Application for a Non-Material Amendment Following a Grant of Planning Permission

Demolition of existing detached dwelling and detached double garage block and erection of a detached dwelling with attached triple garage and indoor swimming pool with associated landscaping to include raised patio areas, steps, footpaths, a timber bridge, a pergola, two mounded copses, a jacuzzi sun deck and replacement front boundary walls/railings and gates.

:22/1164/FFU

Non-Material Amendment(s) Sought

Sheet Title
Plans - Second Level - Proposed GA

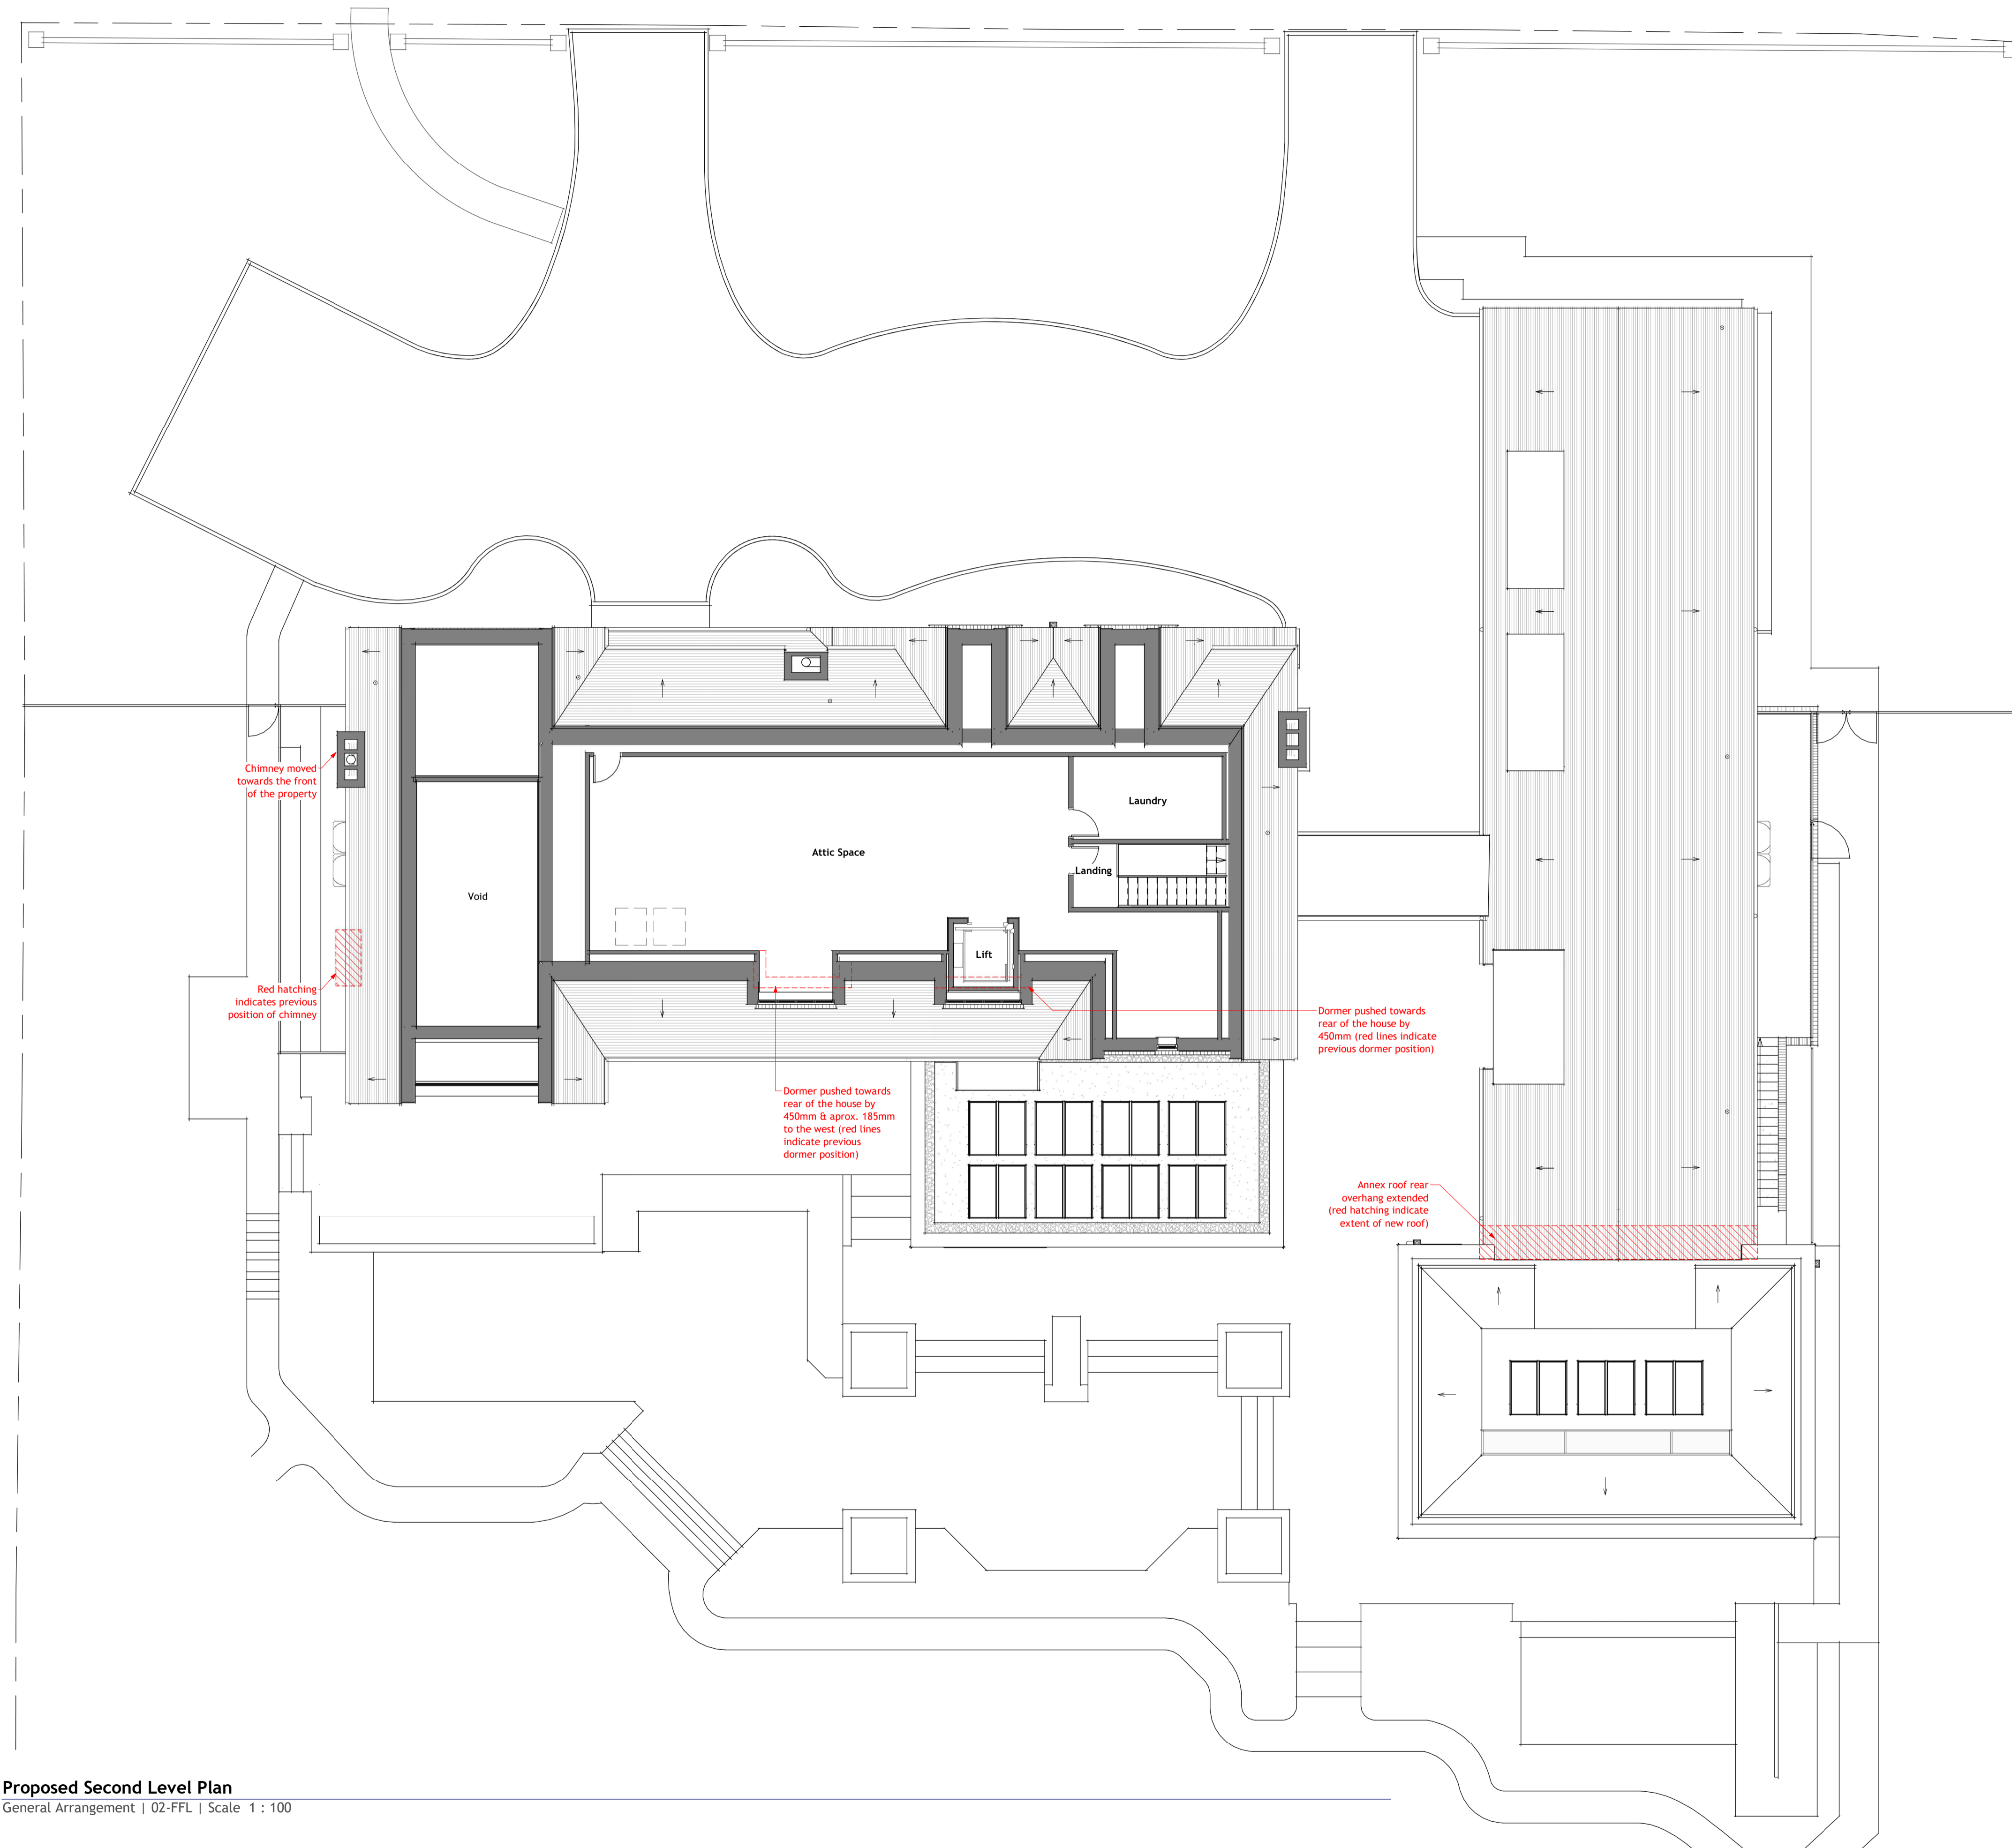
1. Windows size & position revised as shown on plans & elevations
2. Windows removed as shown on plans & elevations
3. New window in the east elevation of the house
4. West chimney moved towards the front of the house as shown on plans & elevations
5. Dormer windows position adjusted as shown on plans & elevations
6. House roof eaves raised & roof pitch reduced by 1No. degree as shown on elevations
7. 2No. rooflights added as shown on plans & elevations
8. Glass roof removed as shown on plans
9. Annex roof rear overhang extended as shown on plans & elevations
10. Annex East wall partly rendered behind fence as shown on elevations
11. Flat rooflight added as shown on plan
